To:	DA Mattox
From:	Thomas Melville
Date:	March 27, 2018
Subject:	SAFEbuilt Permit Review – Design Team Comment Response

The purpose of the memorandum is to capture and provide response to SAFEbuilt Permit Drawing Review Comments for East Tower Expansion as received on March 23, 2018. Drawings are in the processes of being revised and are to be issued as Addendum No. 2 to direct the CM for revisions. Subsequent to this issuance, a full permit set will be issued to SAFEbuilt.

MMC EAST TOWER – BUILDING REVIEW

7A EXPANSION JOINT TRANSITION
3" = 1'-0"

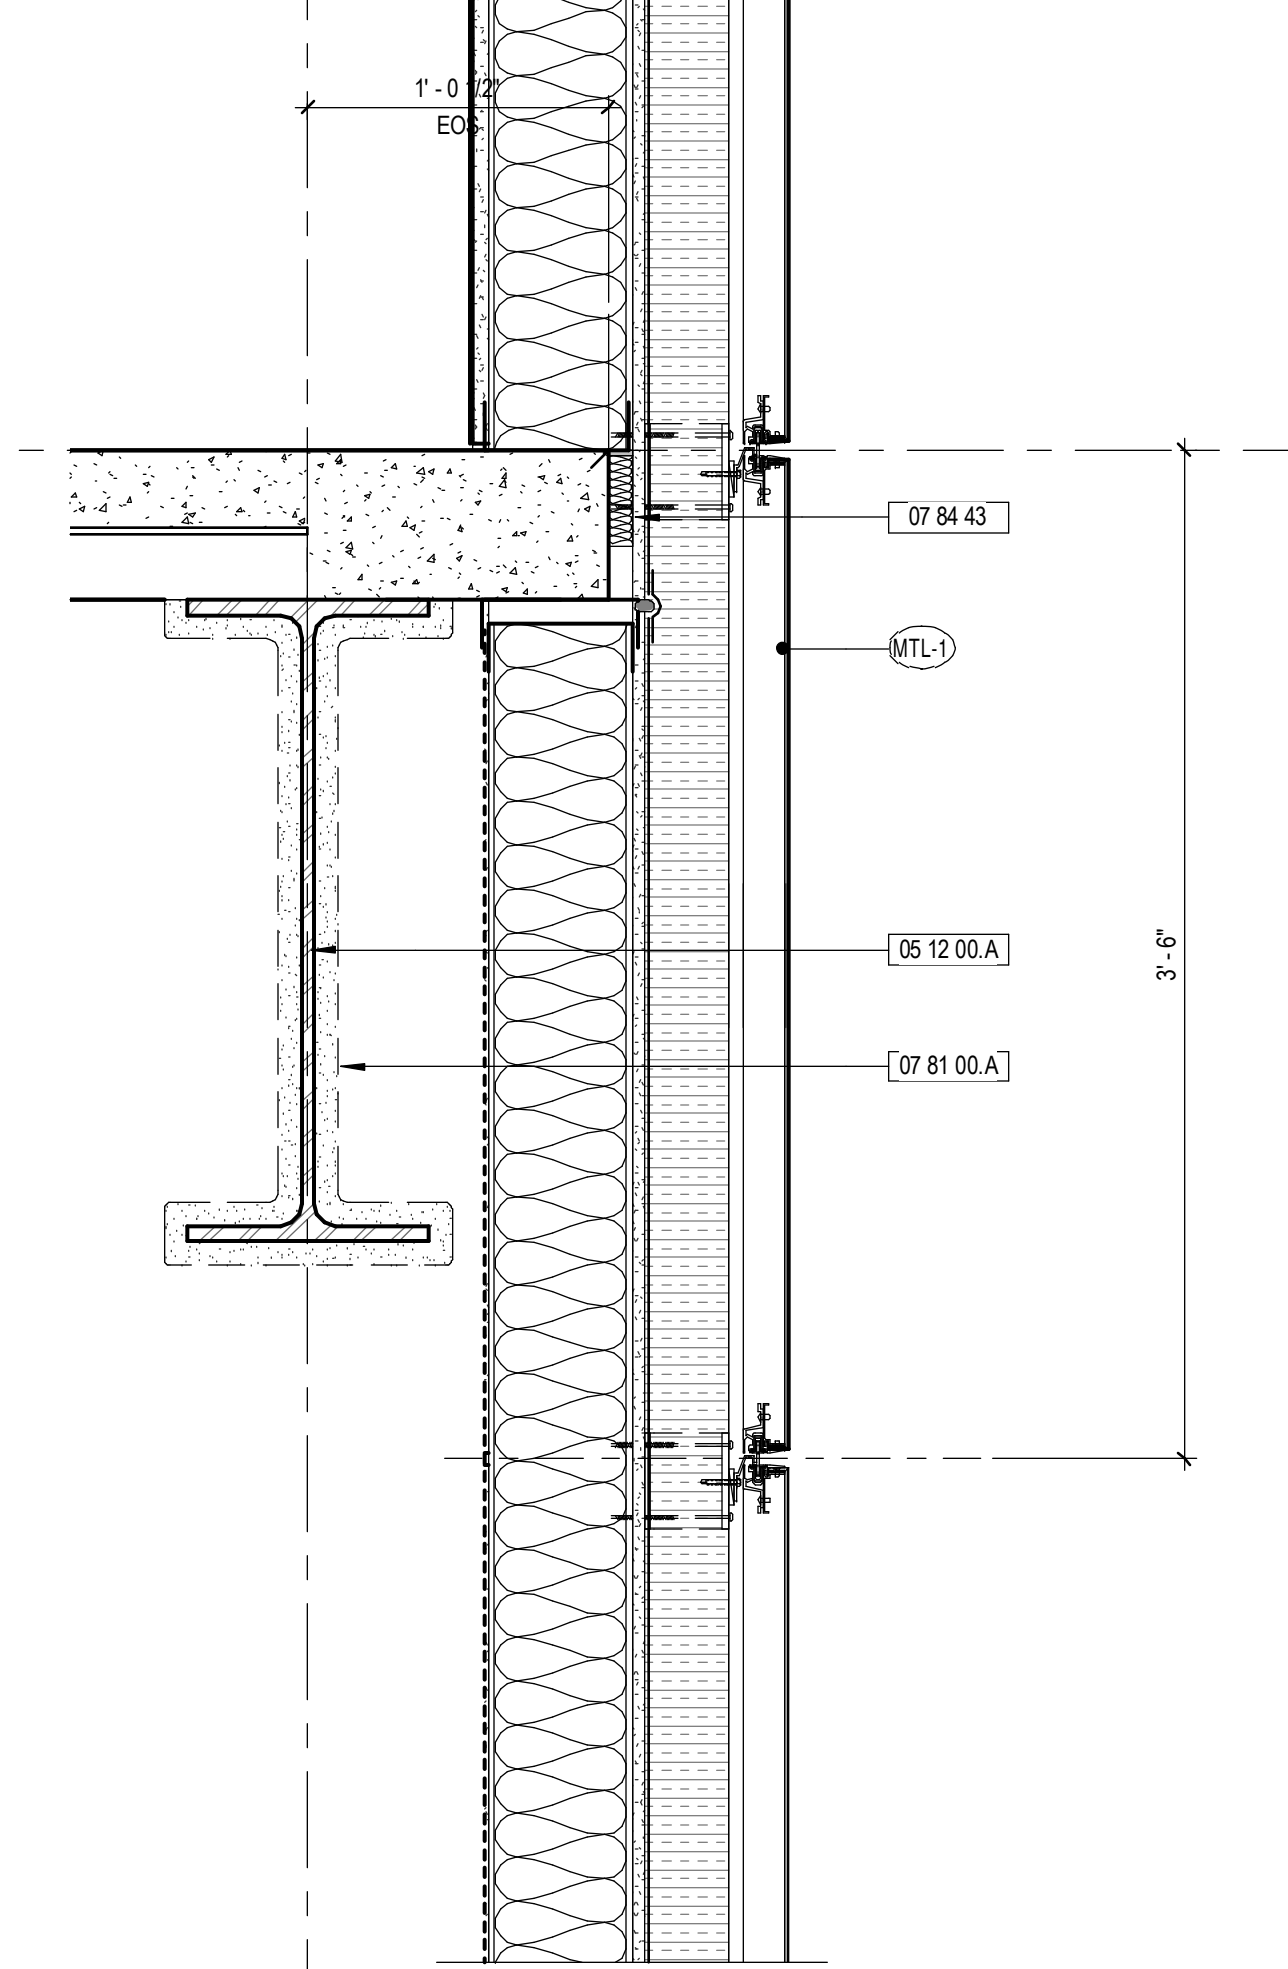
Provide the required fire-resistance ratings for the primary structural frame. A project code summary / analysis is not provided and the various details that show protected primary steel members (exterior section details on sheet A32-01 for example) note the protective material but do not provide a thickness or hour rating.

Exterior section details (sheet A32-04, etc.) specify pressure-treated wood blocking which is not included on the list of permitted combustible materials in Type 1 construction per IBC 603.1.

Fire resistive ratings for primary structural frame provided in Code Report distributed 3/16/2018.

Pressure-treated blocking will be replaced with fire-retardant-treated blocking. This revision will be indicated in Addendum No.2. IBC 603.1 allows fire-retardant-treated wood in non-bearing exterior wall where fire-resistance-rated construction is not required. Refer to Table 602 discussion in Code Report.

SHEET NUMBER
A41-01

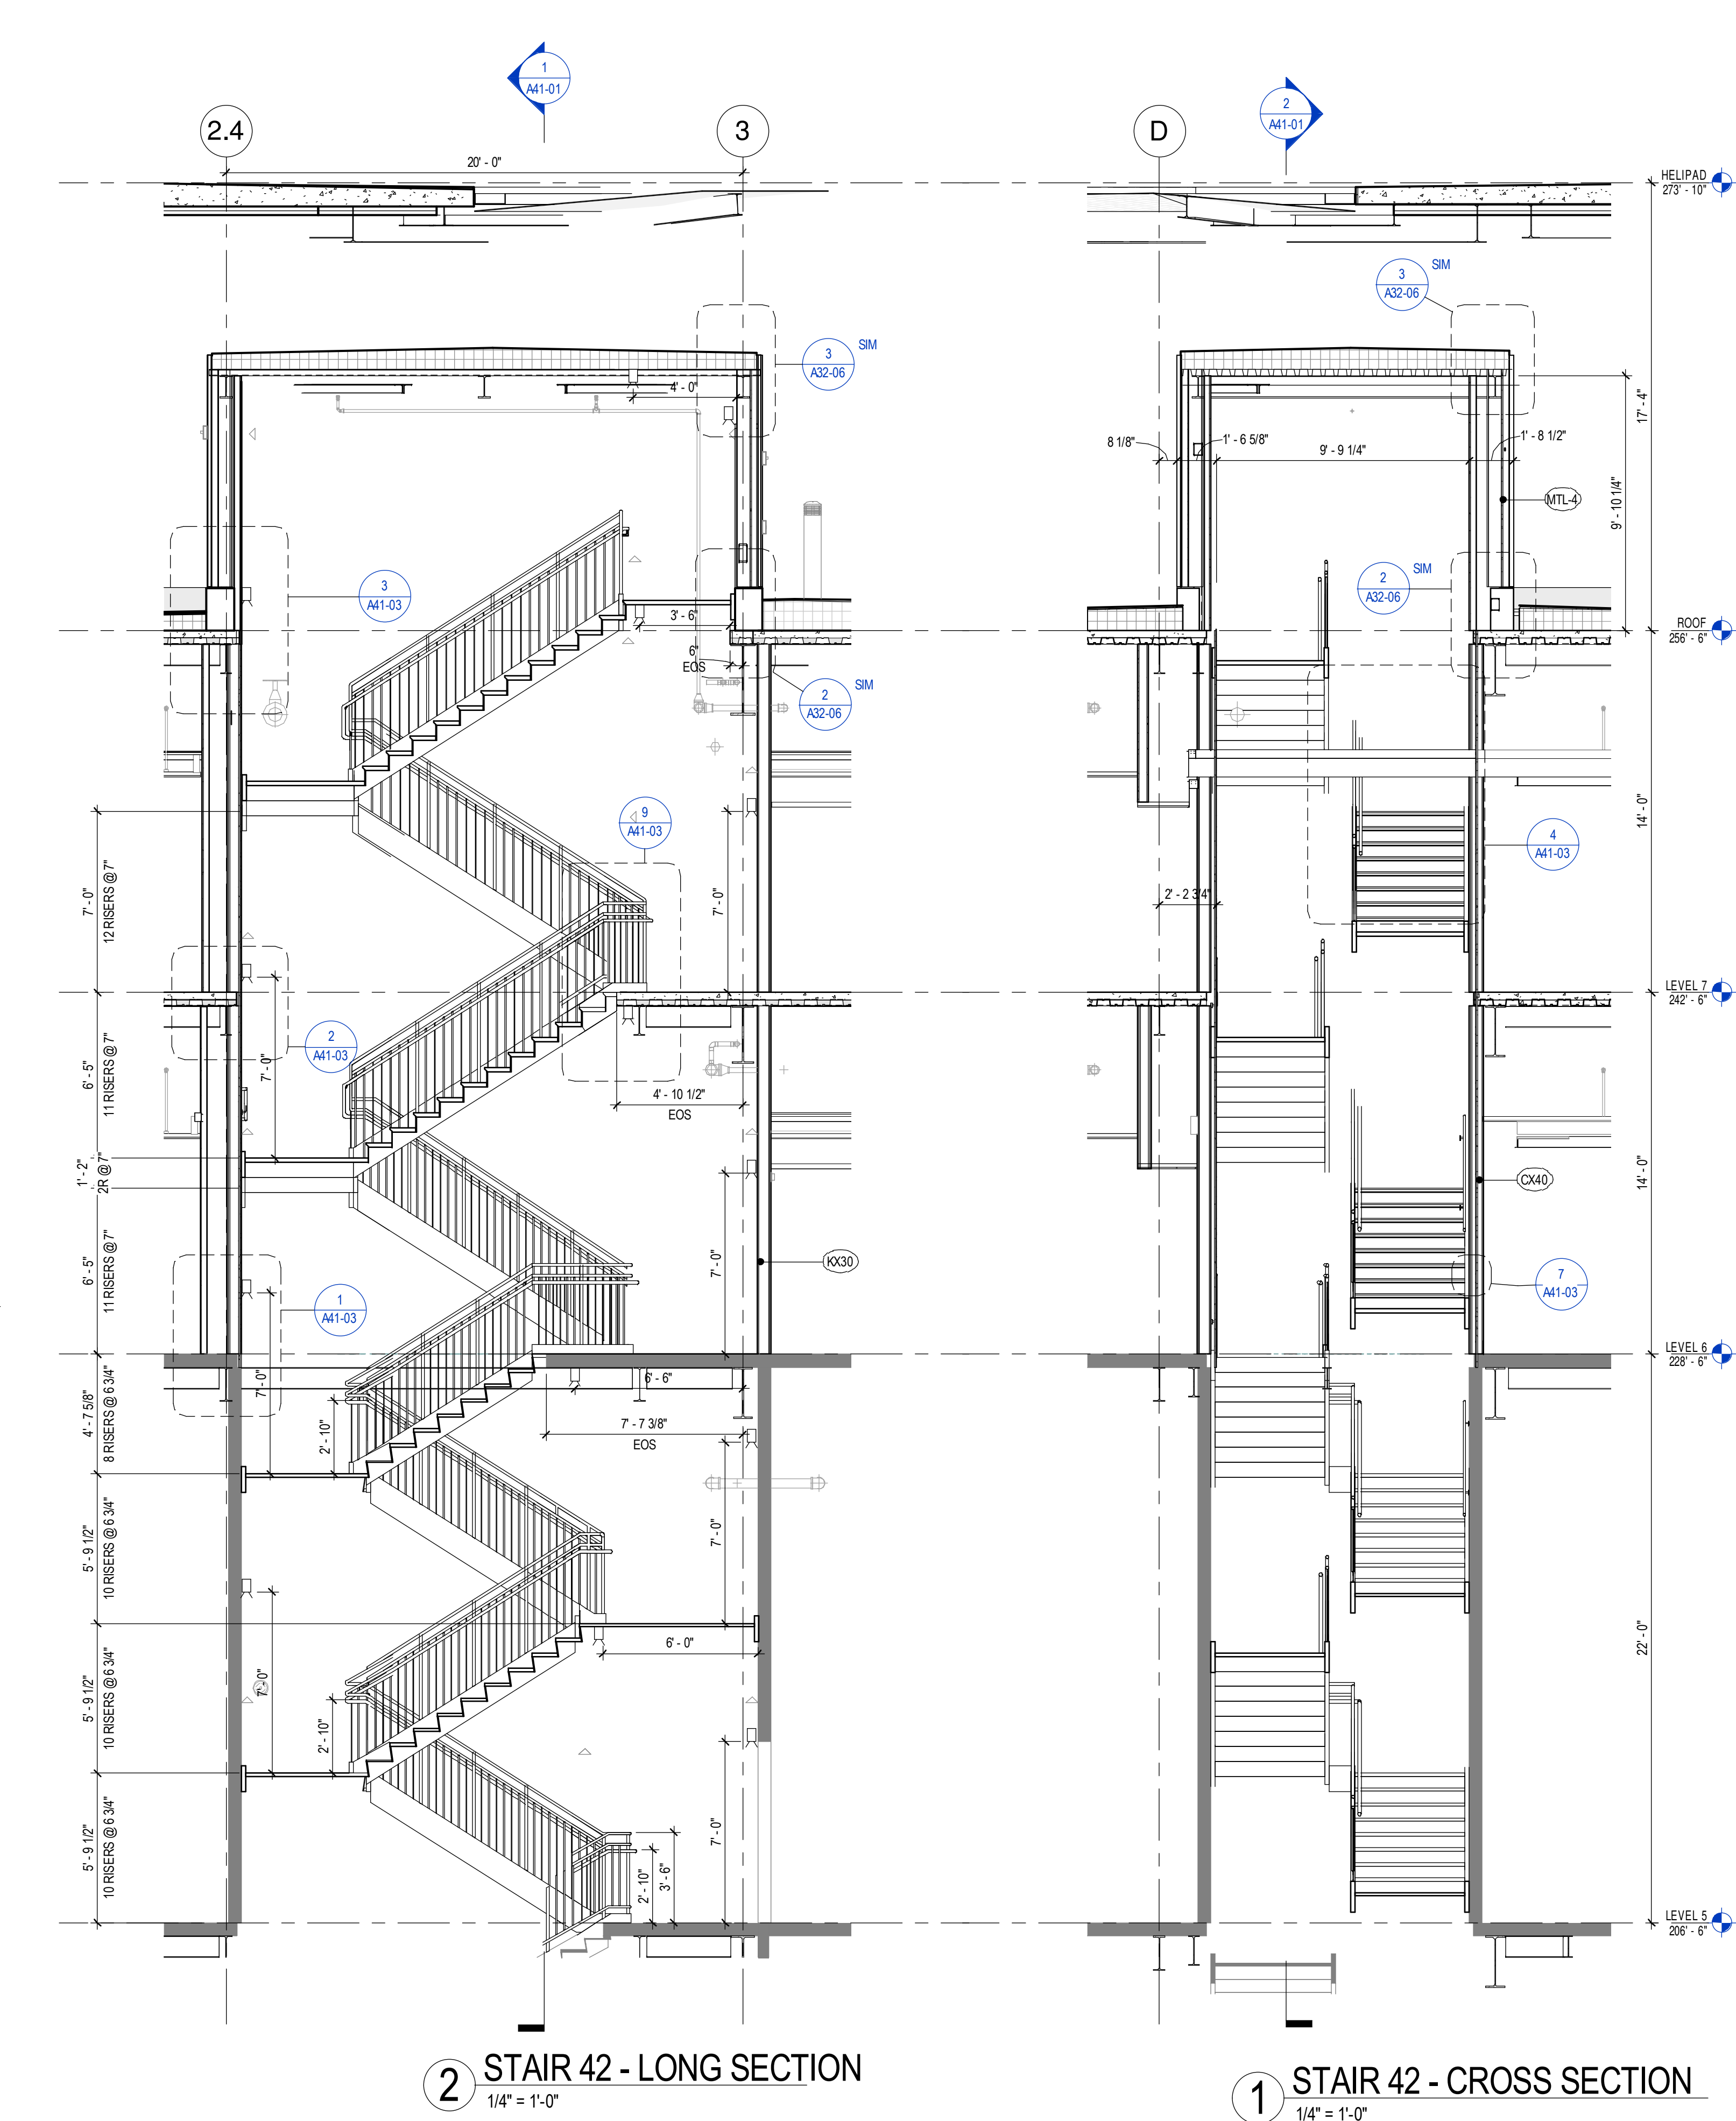
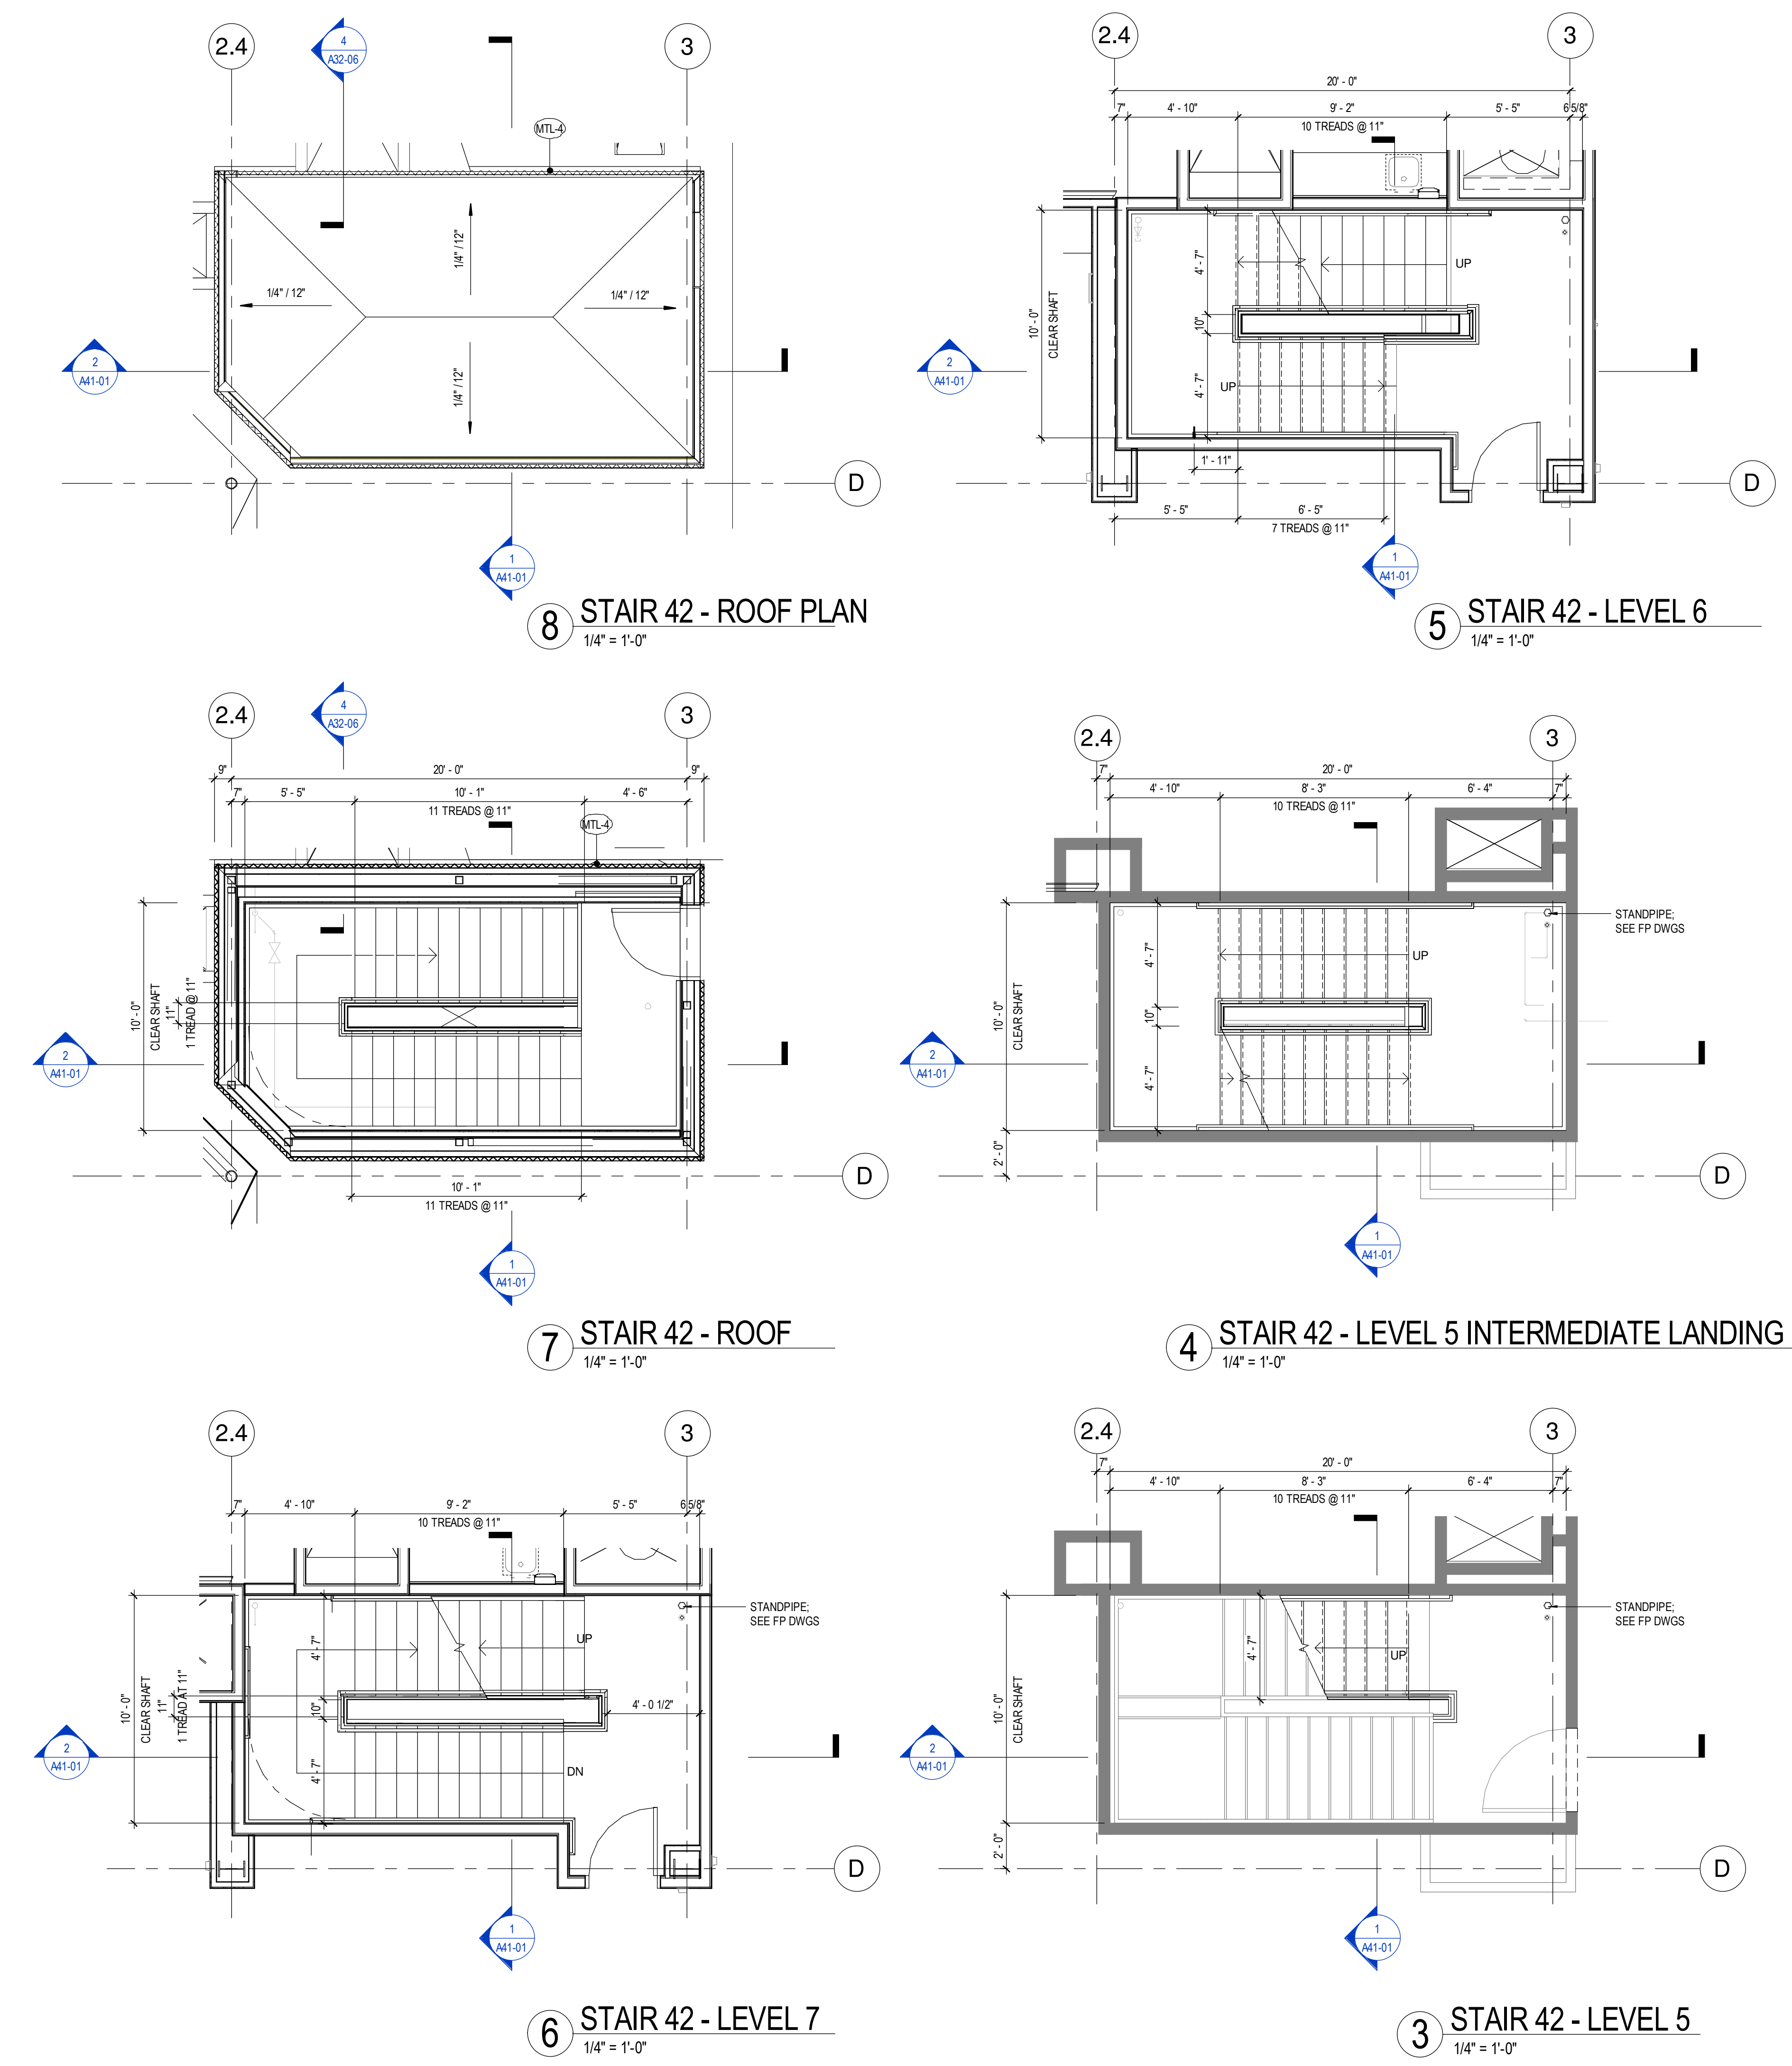
Per IBC 403.5.5 and 1025, luminous egress path markings are required in the interior exit stairs in accordance with IBC.

Required markings are currently indicated within the Documents on Sheets A41-01 and A41-02.
